Re: **Marysville Corporate Center – BSP (PA22004)**
2nd Round Response Letter
Project Number 2200444.00

In response to your plan review checklist dated September 19, 2022, we have addressed the items below, with our responses following your comments.

**SHEET 1 OF 13**

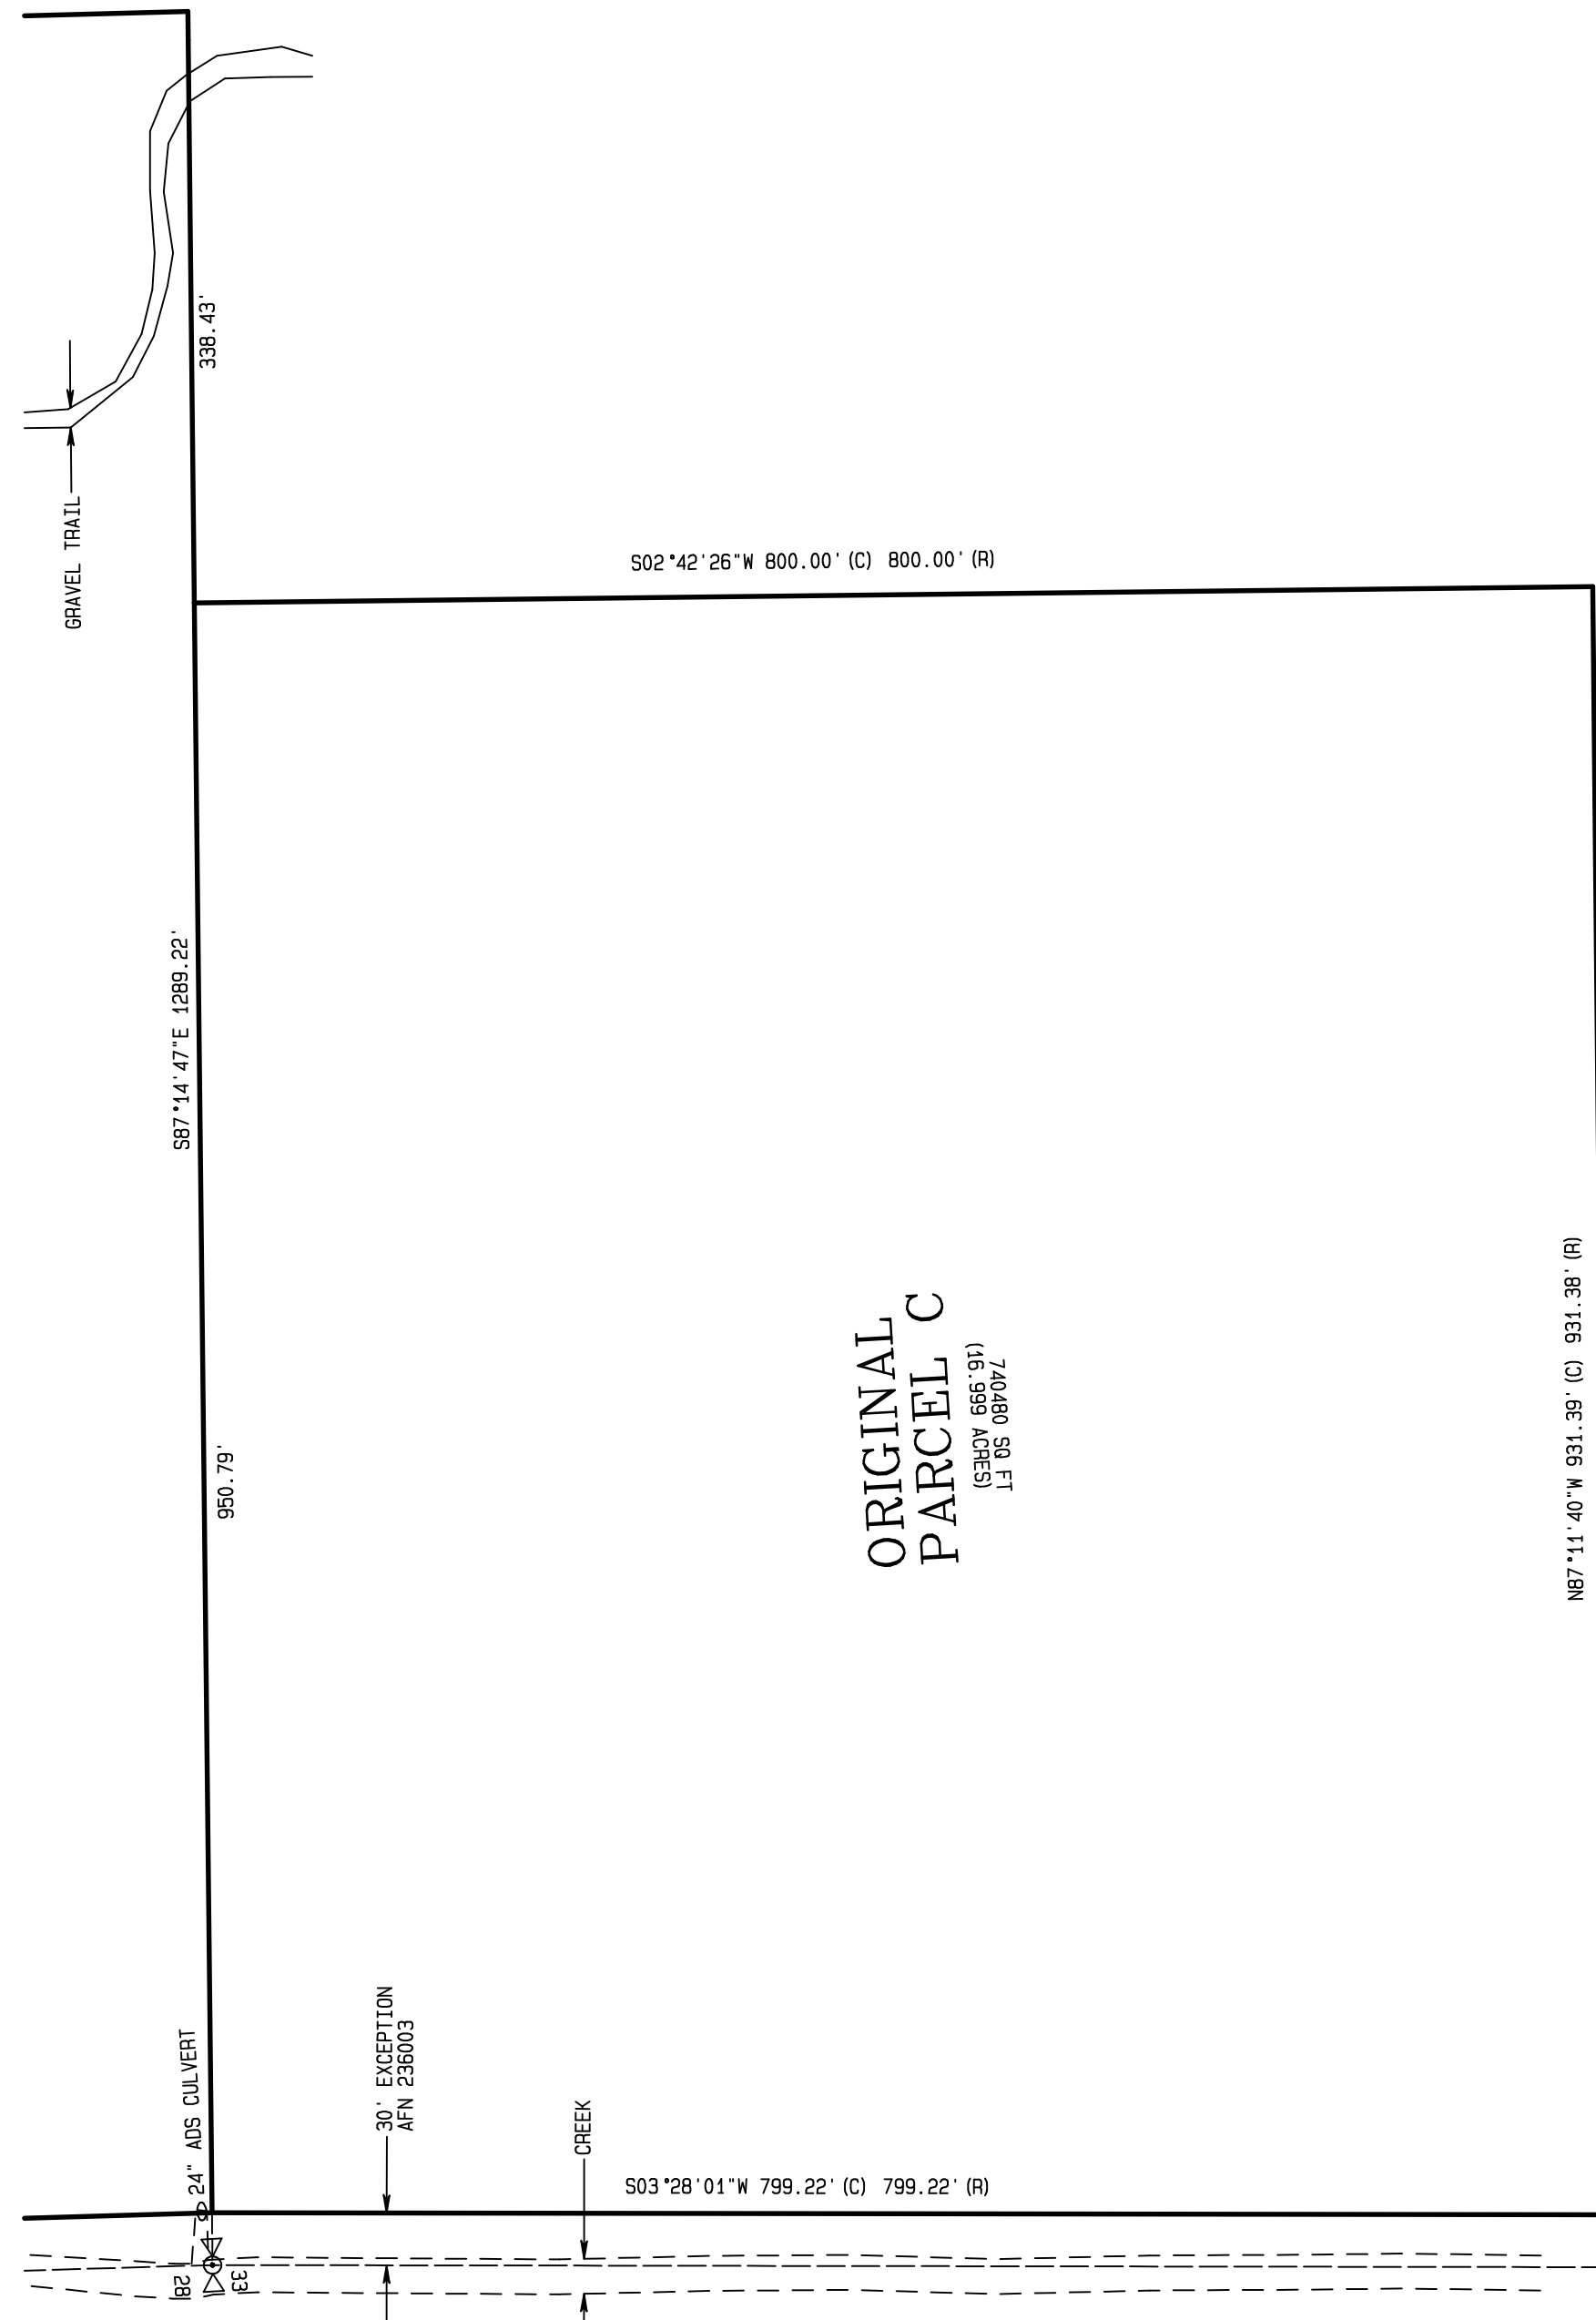
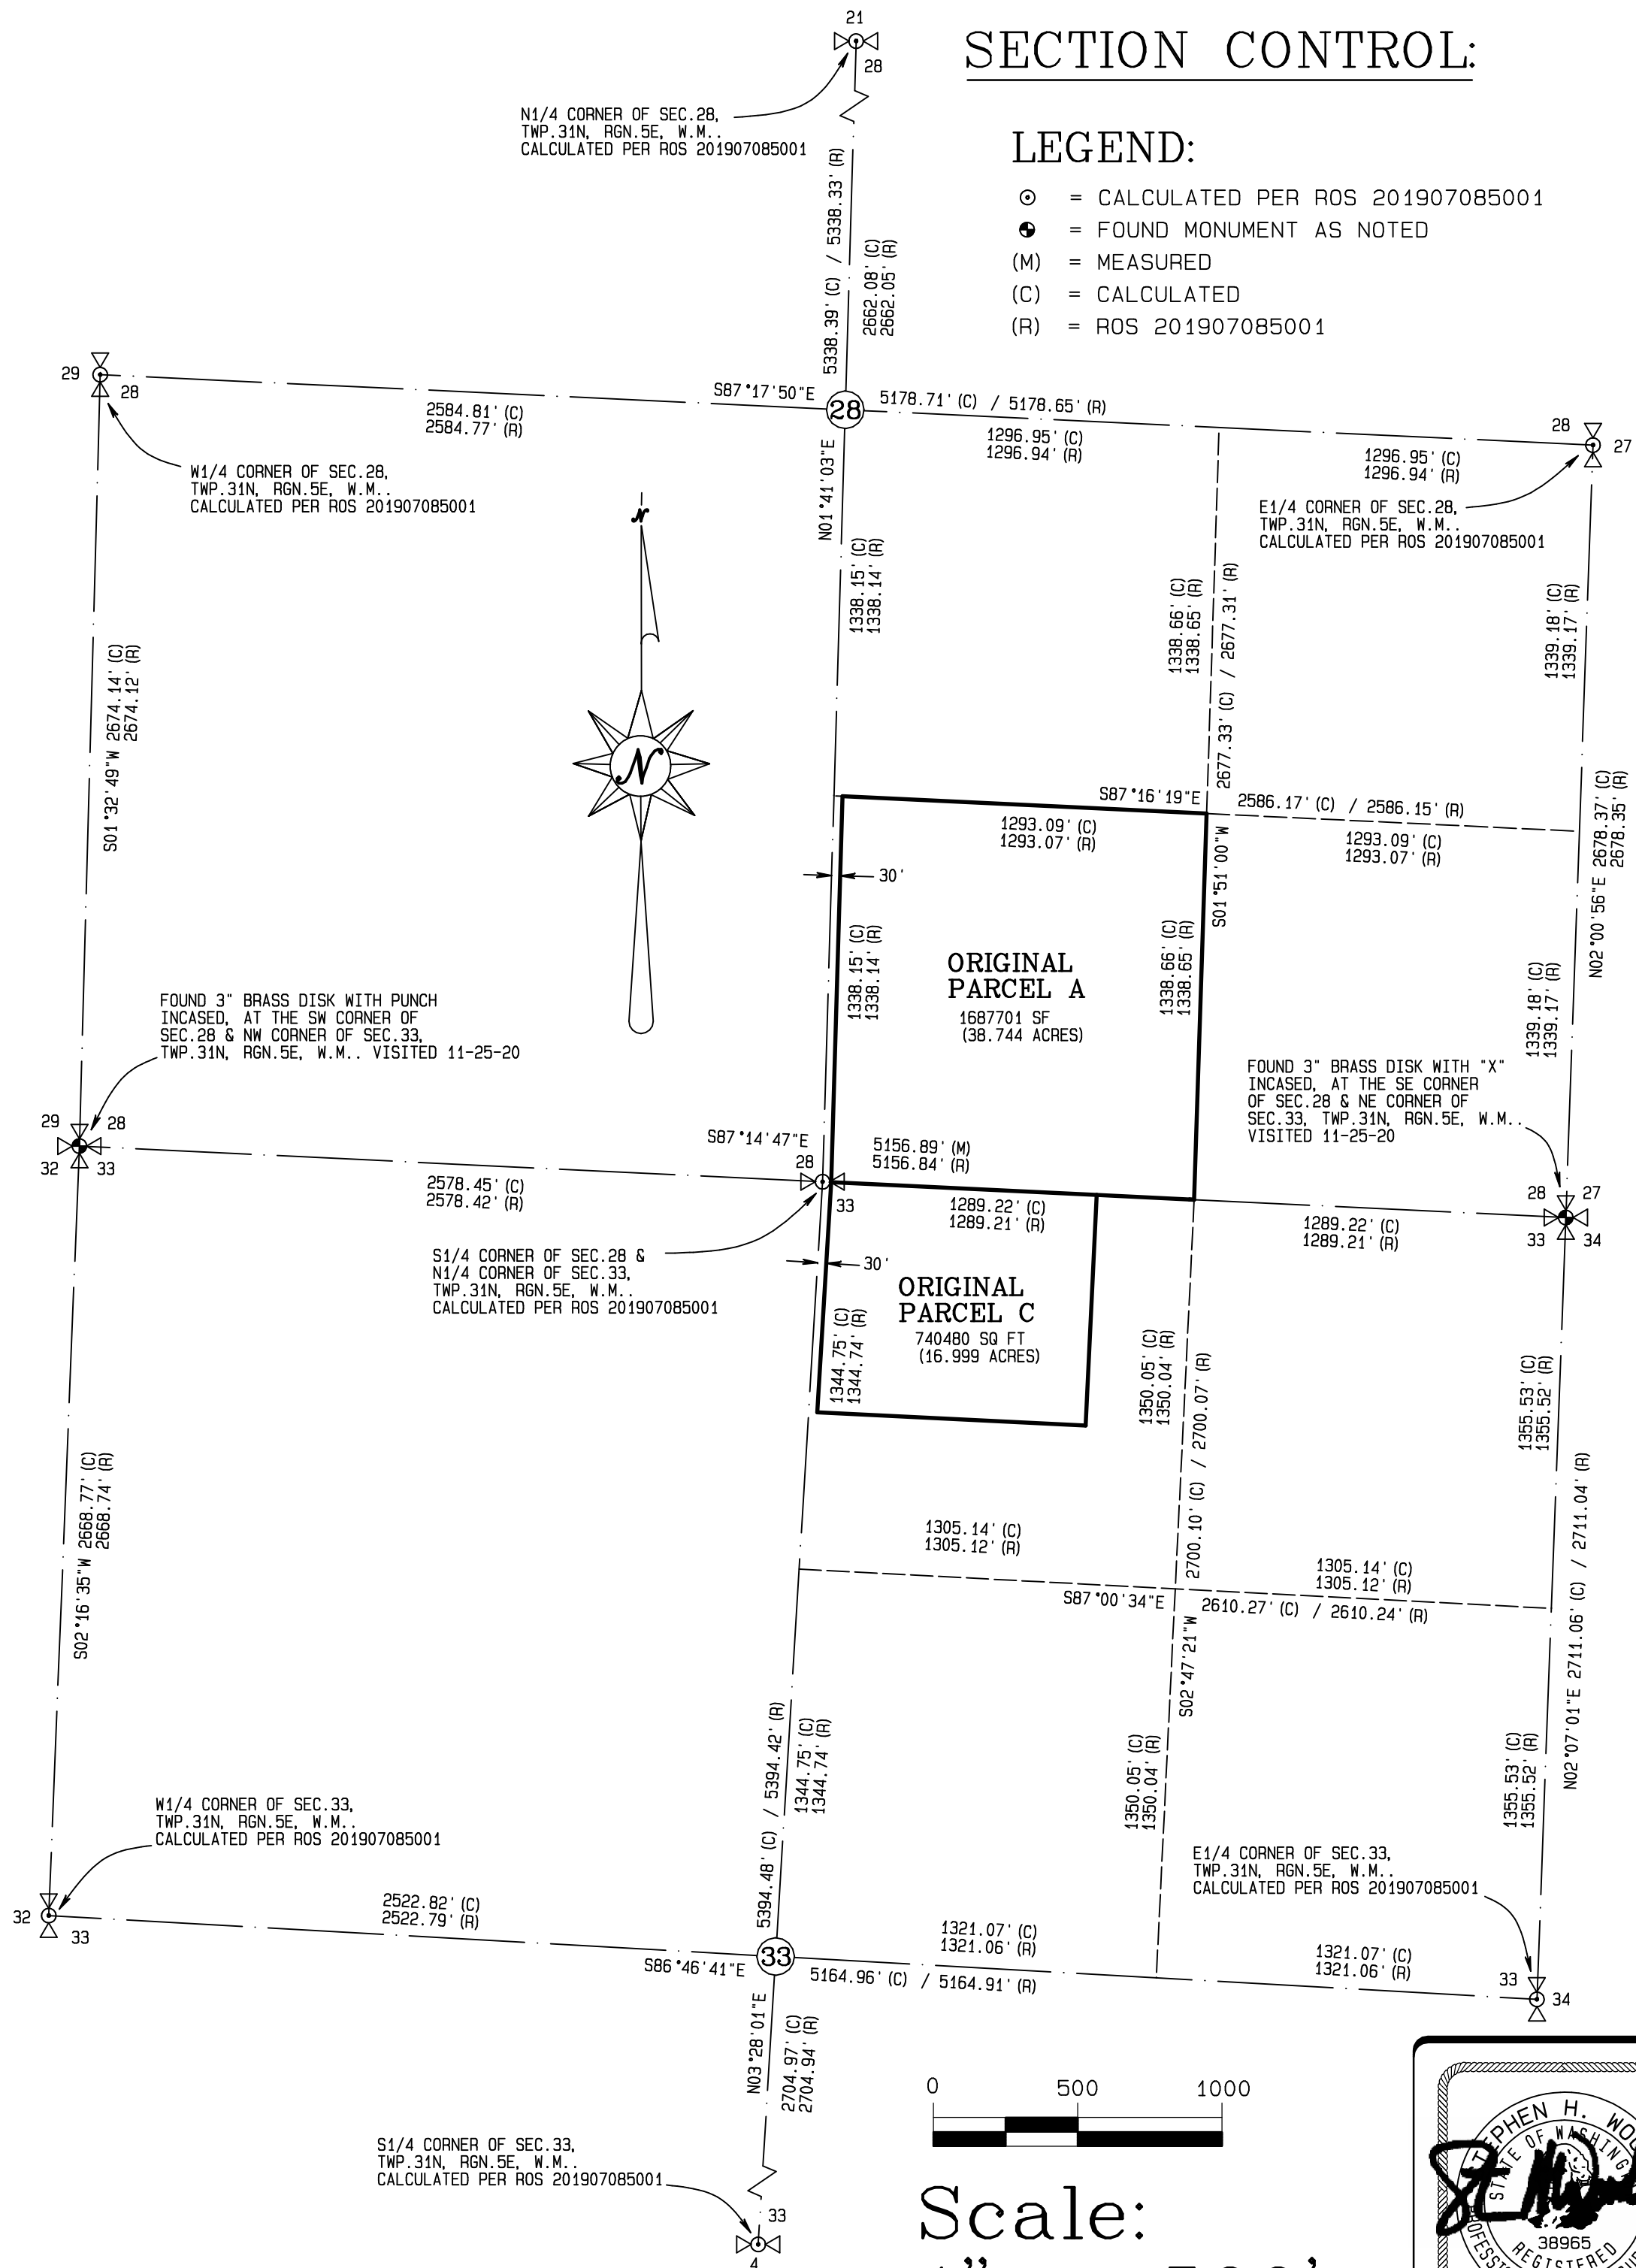
TR2 Comment: *Phasing lines not included on the cover sheet.*

Additionally, remove "SHEET 5 OF 8" and "SHEET 6 OF 8" from Sheet 1. These are not correct references and are not needed.

- l. Provide a Table that identifies each TRACT the SF and proposed Use of the TRACTS.*

- m. Sheet 4 of 8 includes a "ZONING COMPLIANCE – TOTAL PHASE" section. Confused what this information is representing? Compliance with the LI bulk & dimensional standards as outlined in [MMC 22C.020.080\(2\)](#) is required. What is "Landscape Area," "Sidewalk/Drive Aisle Area" and "Building Area," and what Phase is it for? The setbacks noted are incorrect, the base height allowance is not noted and the math for the maximum impervious surface is not provided. Please amend and provide the additional information noted.*

Response: Phasing lines are included; see sheet 1 or 13.

Response: Note has been removed.

Response: Table has been provided on sheet 1 of 13.

Response: Zoning compliance data is provided on sheet 1 of 13.

INDEX DATA: SEC 28-33 T 31N R 5E WM
SURVEY FOR: PACIFIC REALTY ASSOCIATES, L.P. 15908 47TH AVE NE MARYSVILLE, WA 98271
SNOHOMISH COUNTY, WASHINGTON
SHEET 6 OF 13

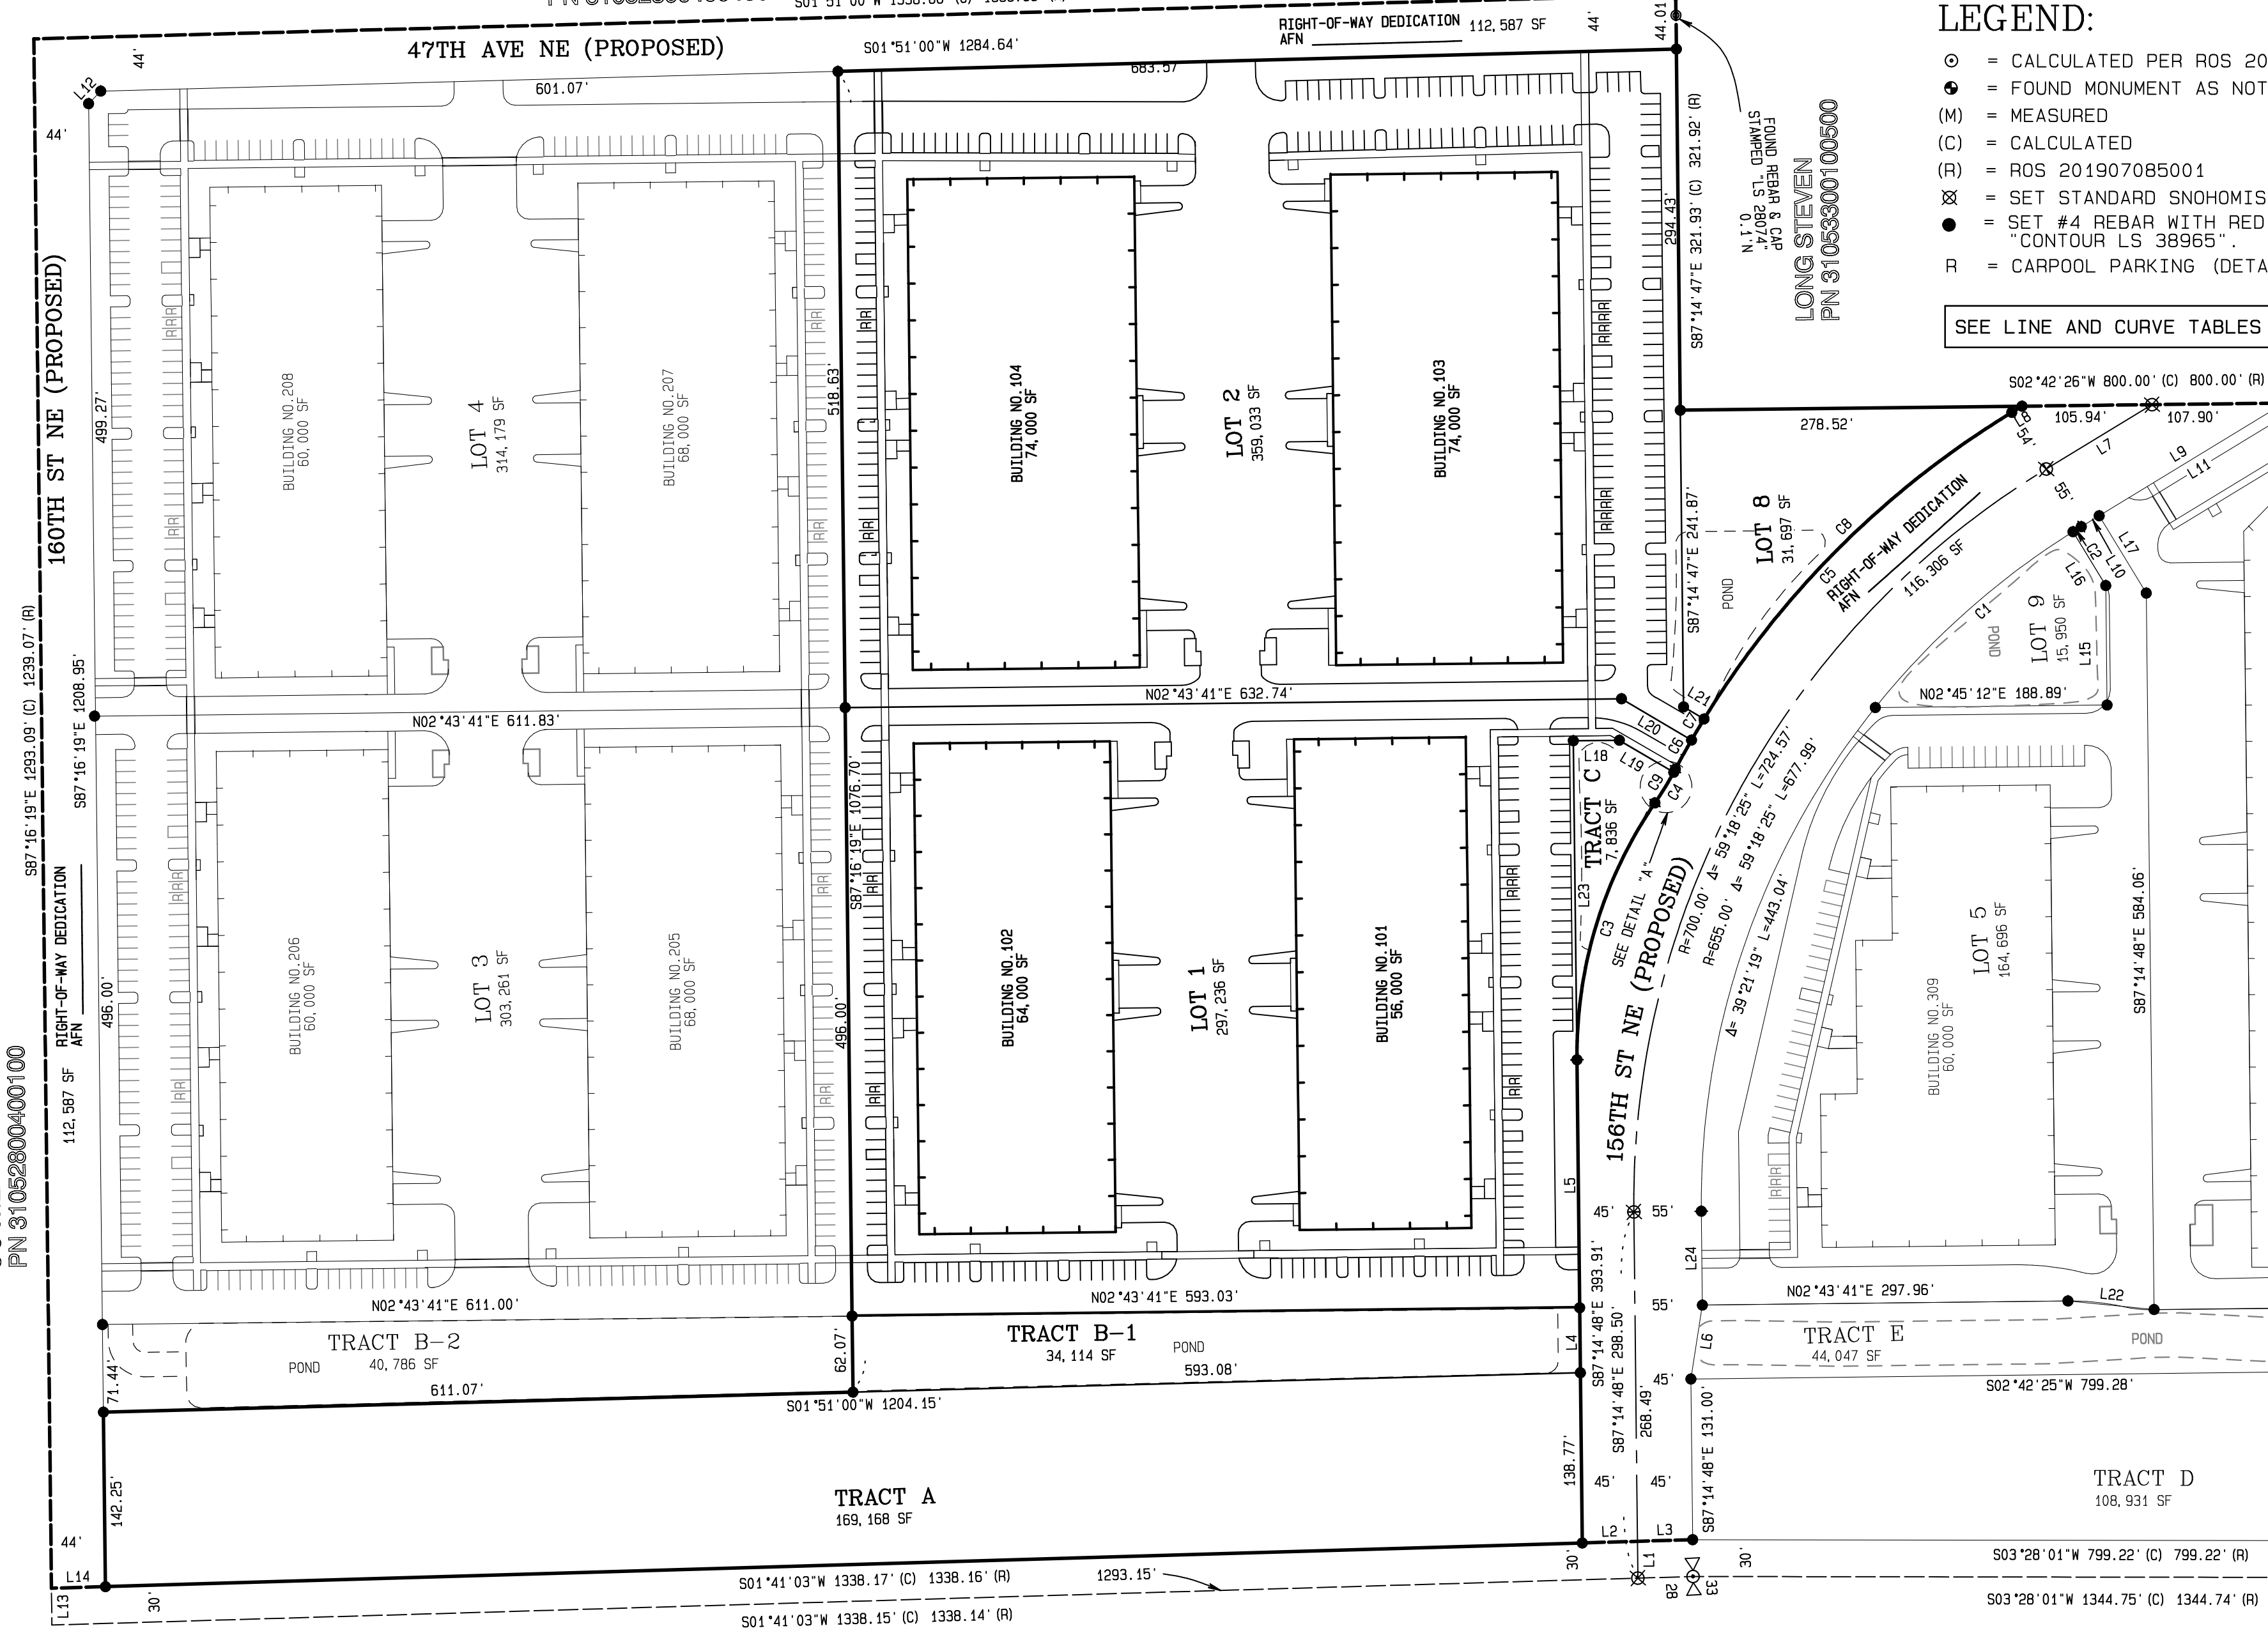
TR2 Comment: No phase lines have been identified and Phases 2 & 3 are NOT drawn in light colored shadow print.

Response: Phase 2 and 3 improvements are drawn in in lighting colored shadow print; see page 6 of 13.
